Substantive response from the Health and Safety Executive (HSE) to the local planning authority (LPA) as a statutory consultee.

To LPA	Kirklees Council
LPA planning ref no	2021/62/93305/W
Our ref	pgo-0675
Site address	61-65, New Street, Huddersfield, HD1 2BQ
Proposal description	Change of use and conversion of existing buildings, erection of split-level seven storey extension comprising four-storey stairwell, five-storey roof-top tower block and enclosed courtyard to form 31 dwellings and sub-division of the retail unit forming 61-63 New Street (Listed Building within a Conservation Area).
Date on fire statement (Date the fire statement was completed)	29/09/2021
Date application received (Date HSE received notification from LPA)	08/12/2021
Date response sent (Date HSE sent substantive response to LPA)	14/12/2021

Headline Response from HSE ('Advice to LPA' - Significant Concern)

ELEVATION 5 - (PARTIAL) RAMSDEN STREET

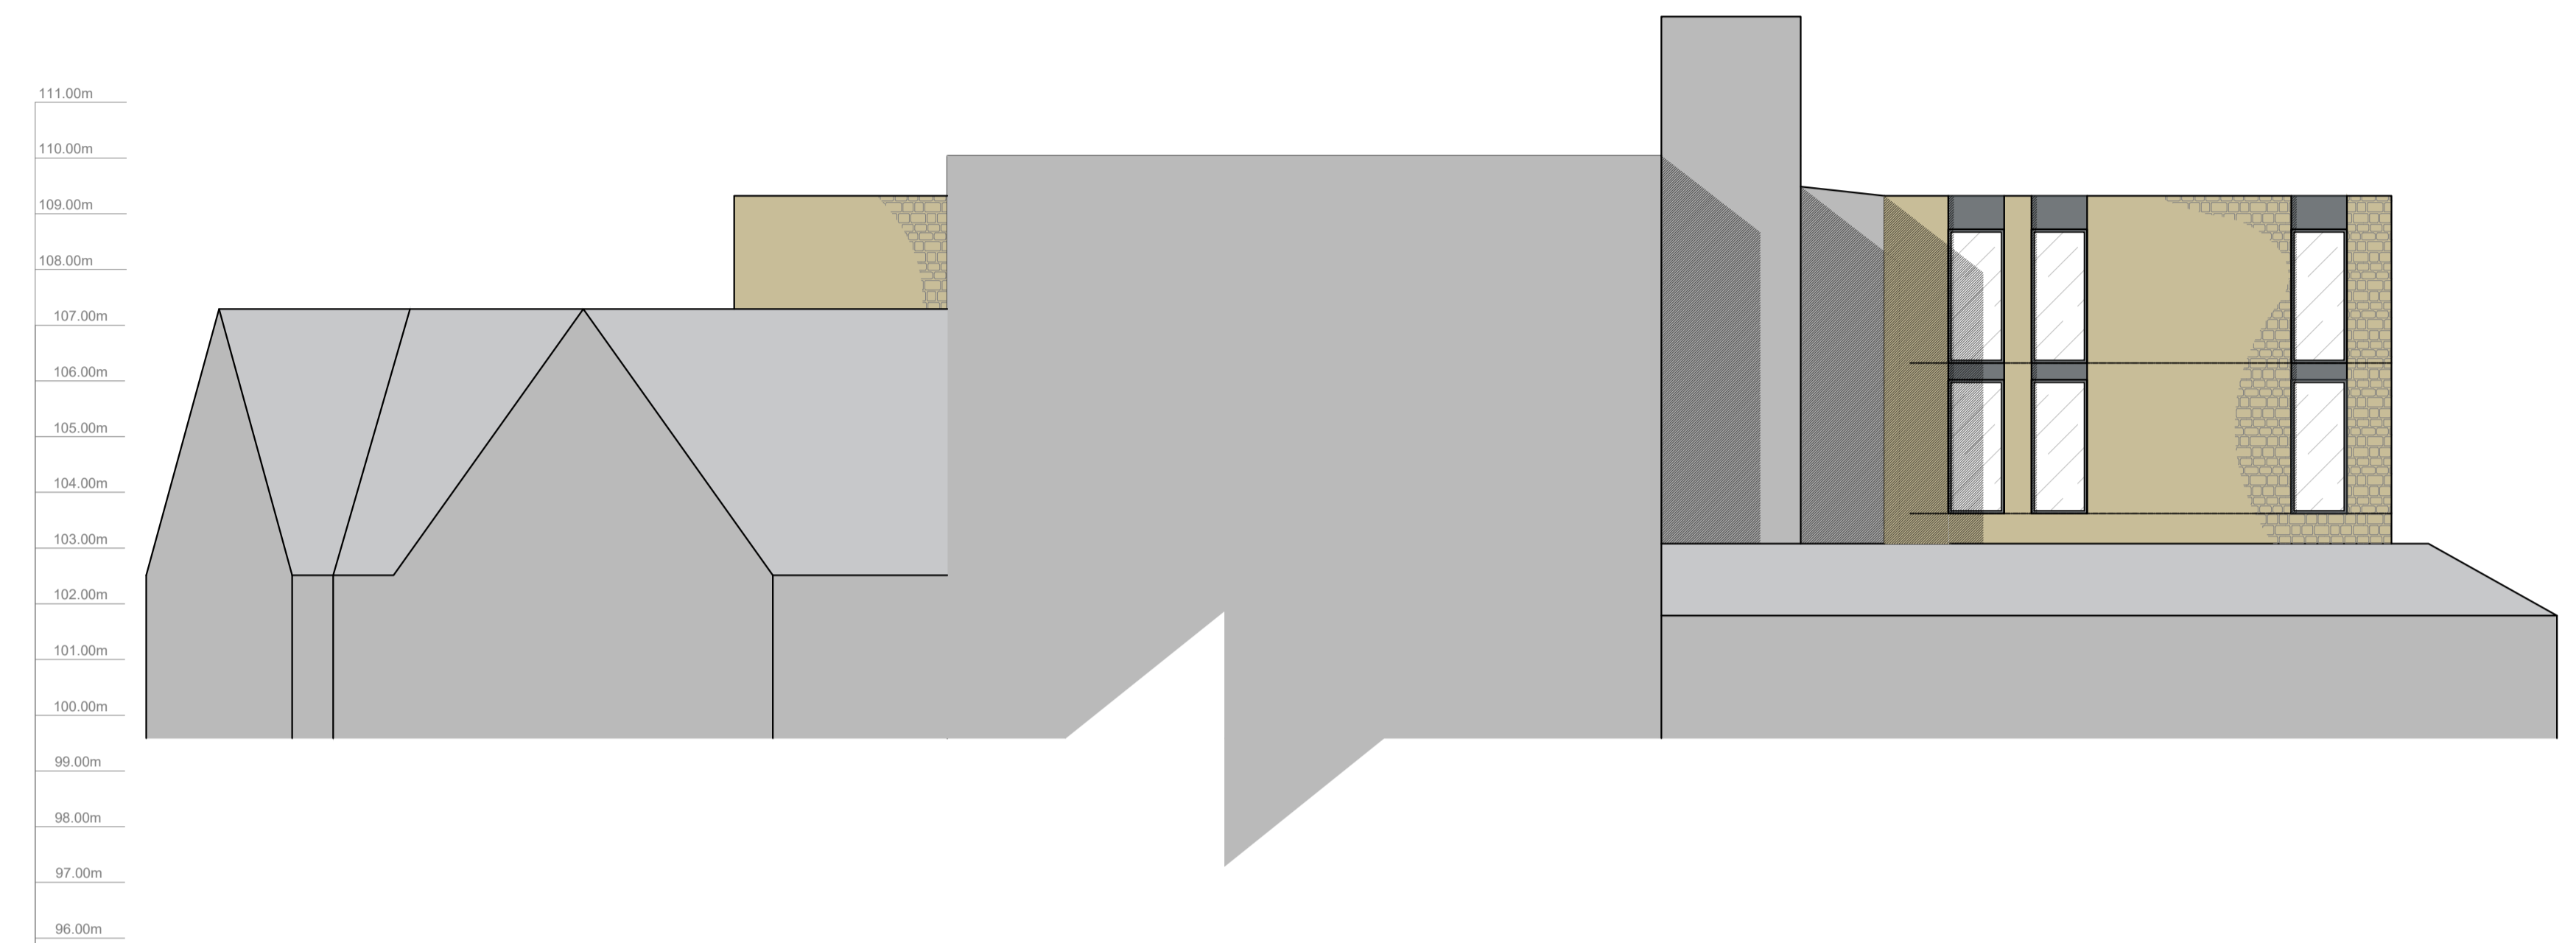
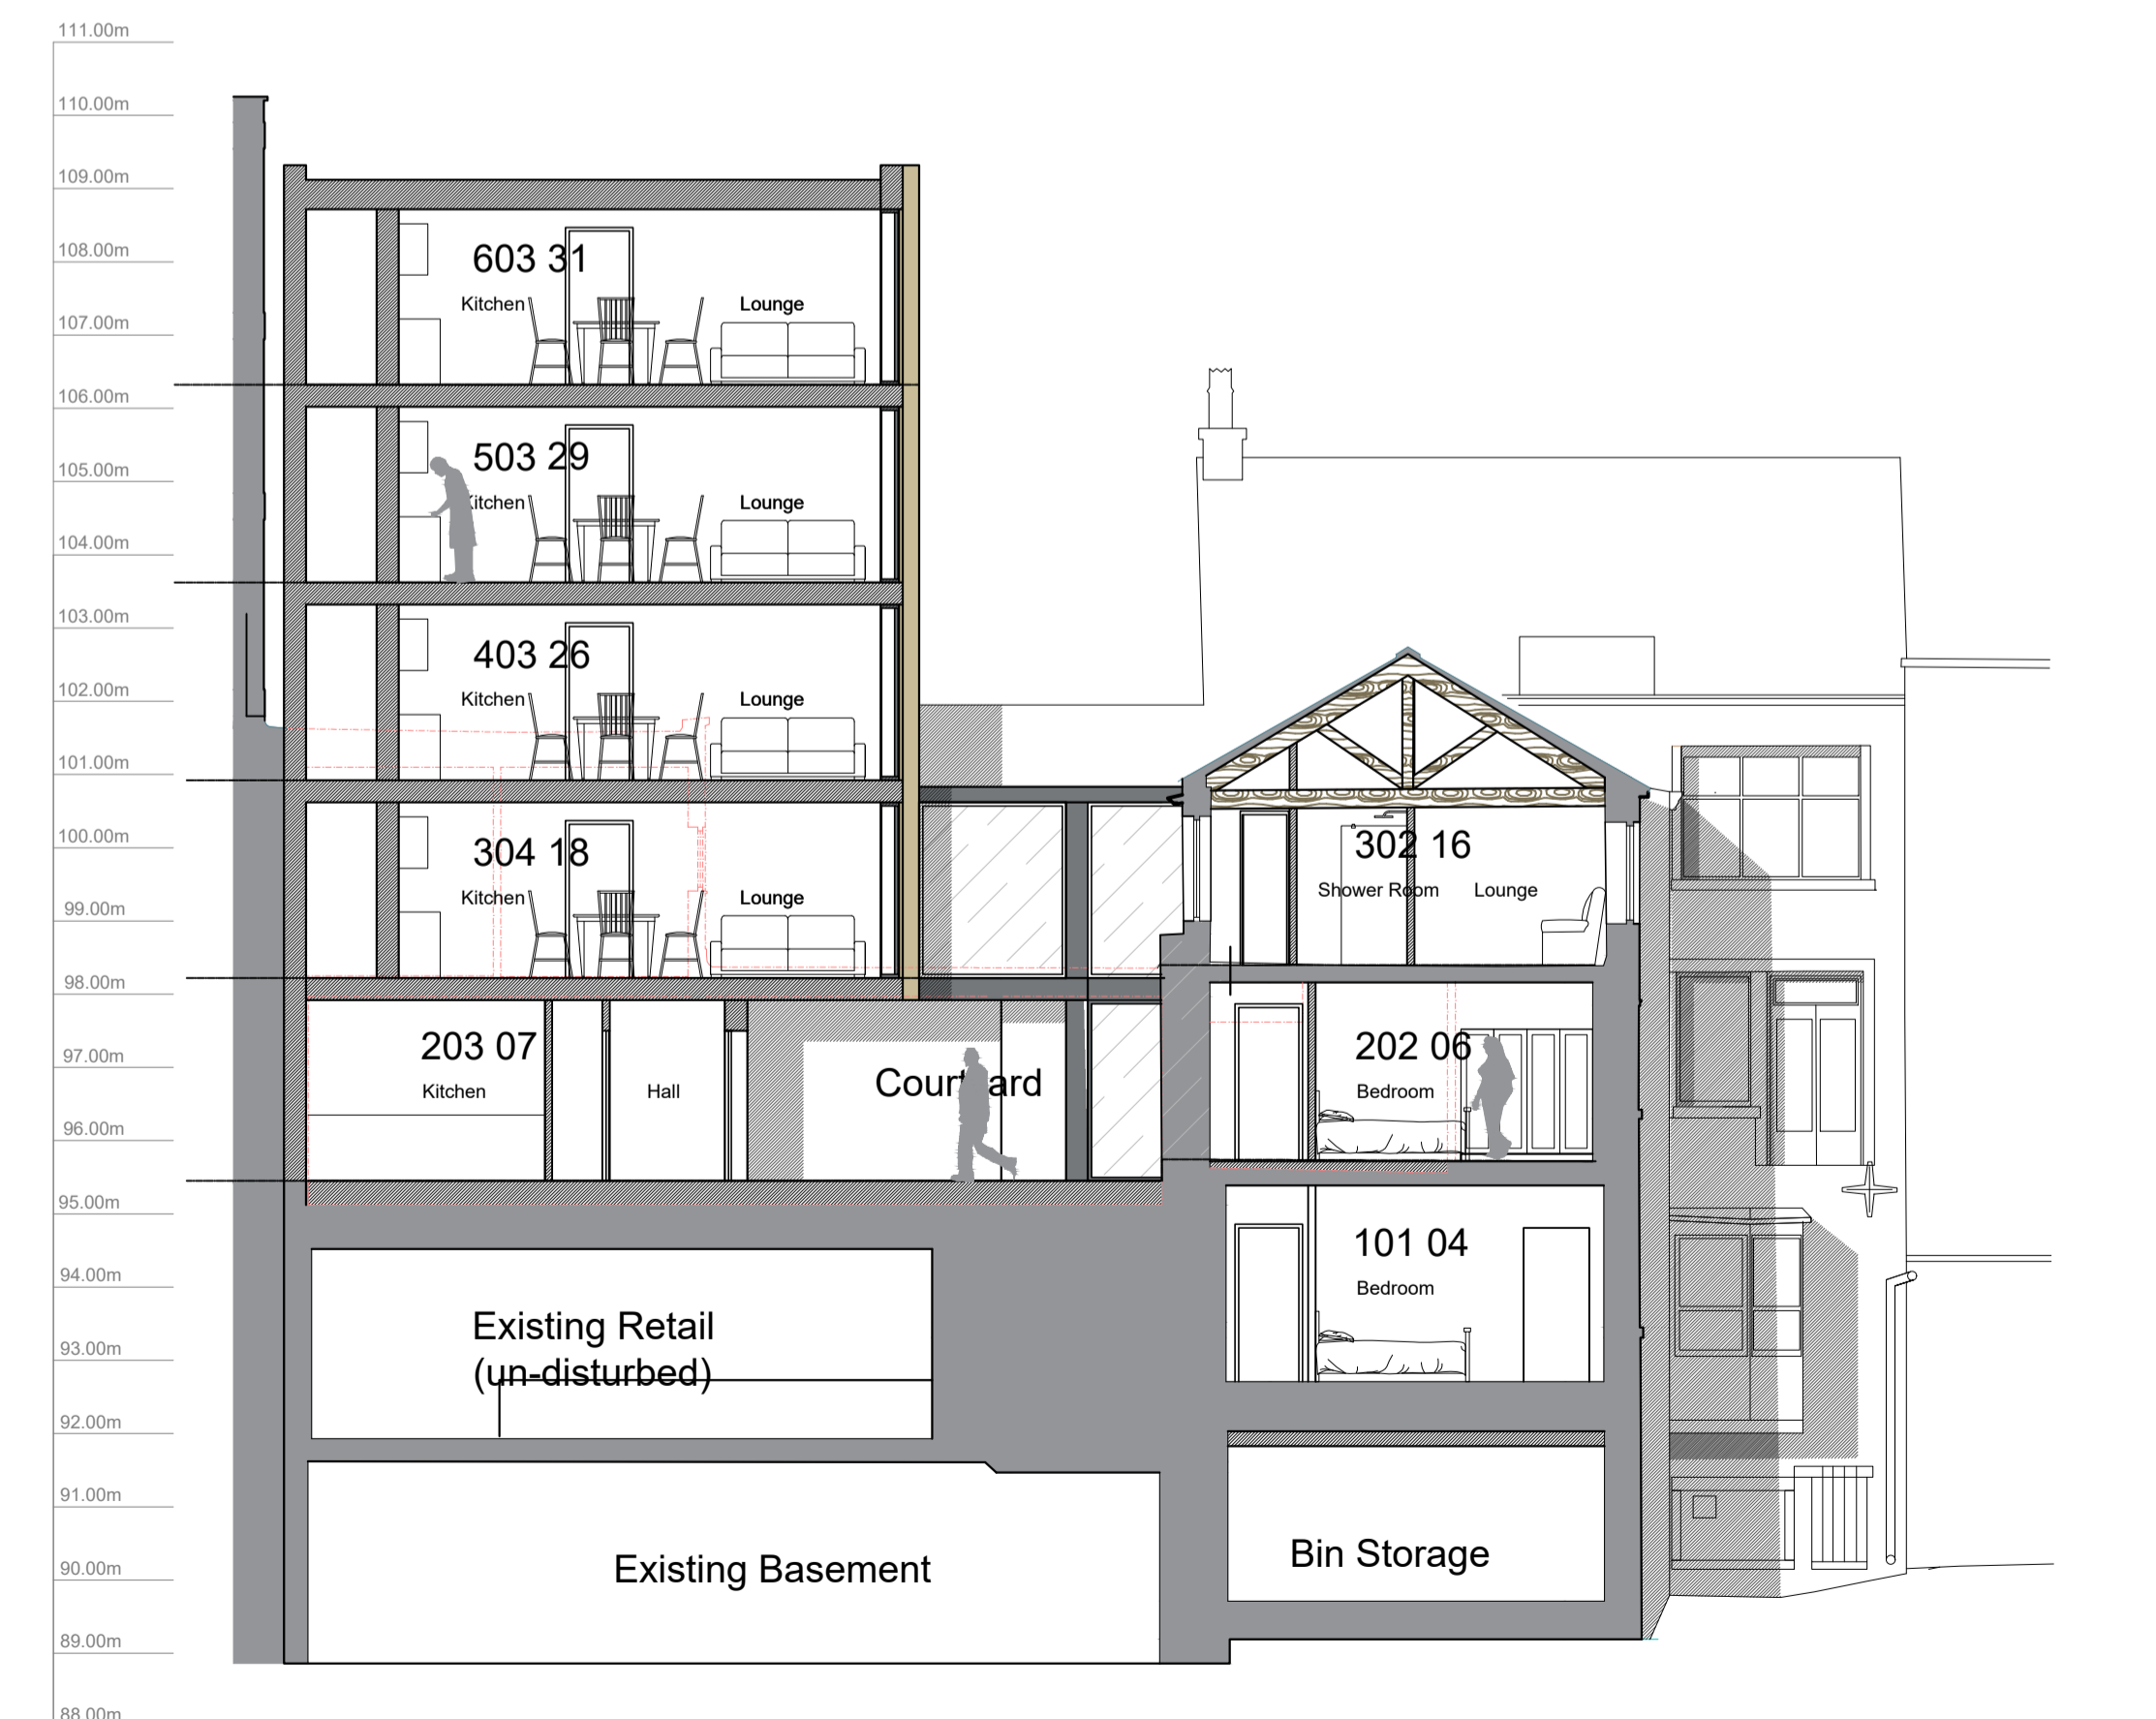
- 1.1 The fire statement indicates at section 6 that block 5 will consist of 7 storeys excluding those storeys below ground level. This is consistent with plan drawings in the Structural Inspection Report, and Phase 1 Desk Study Report, which show basement, ground and first to sixth floors, making seven storeys. However, this is inconsistent with the elevation shown in drawing (100)21, which shows basement, ground and five upper storeys.

PROPOSED SECOND FLOOR GENERAL ARRANGEMENT PLAN

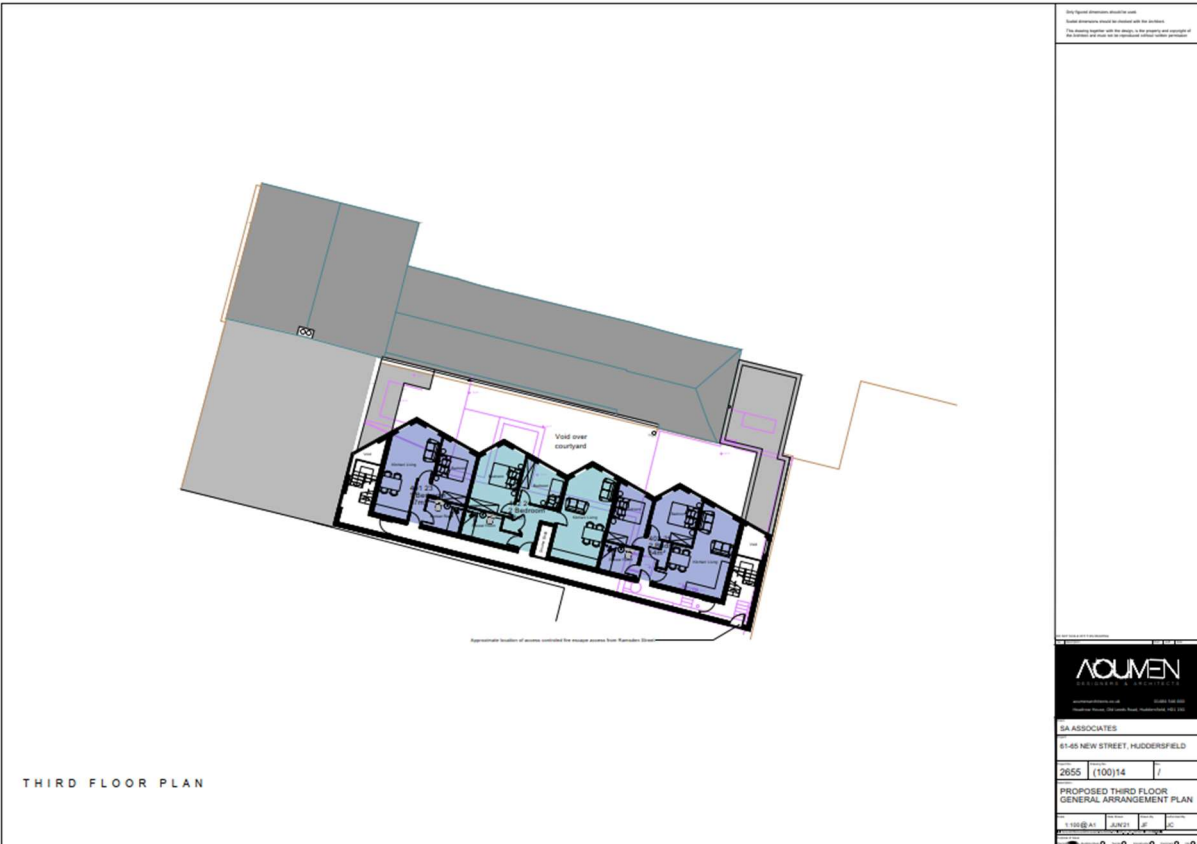
2.8 Plan drawings of several storeys show that the escape routes from flats are via lobbies between the flat door and staircase. Lobbies between flat doors and stairs require smoke ventilation to ensure that the escape route is kept free of smoke. However, it is not clear how smoke vents can be provided in lobbies with the proposed layout. Resolving this issue may affect land use planning considerations such as design, density and layout of the building.
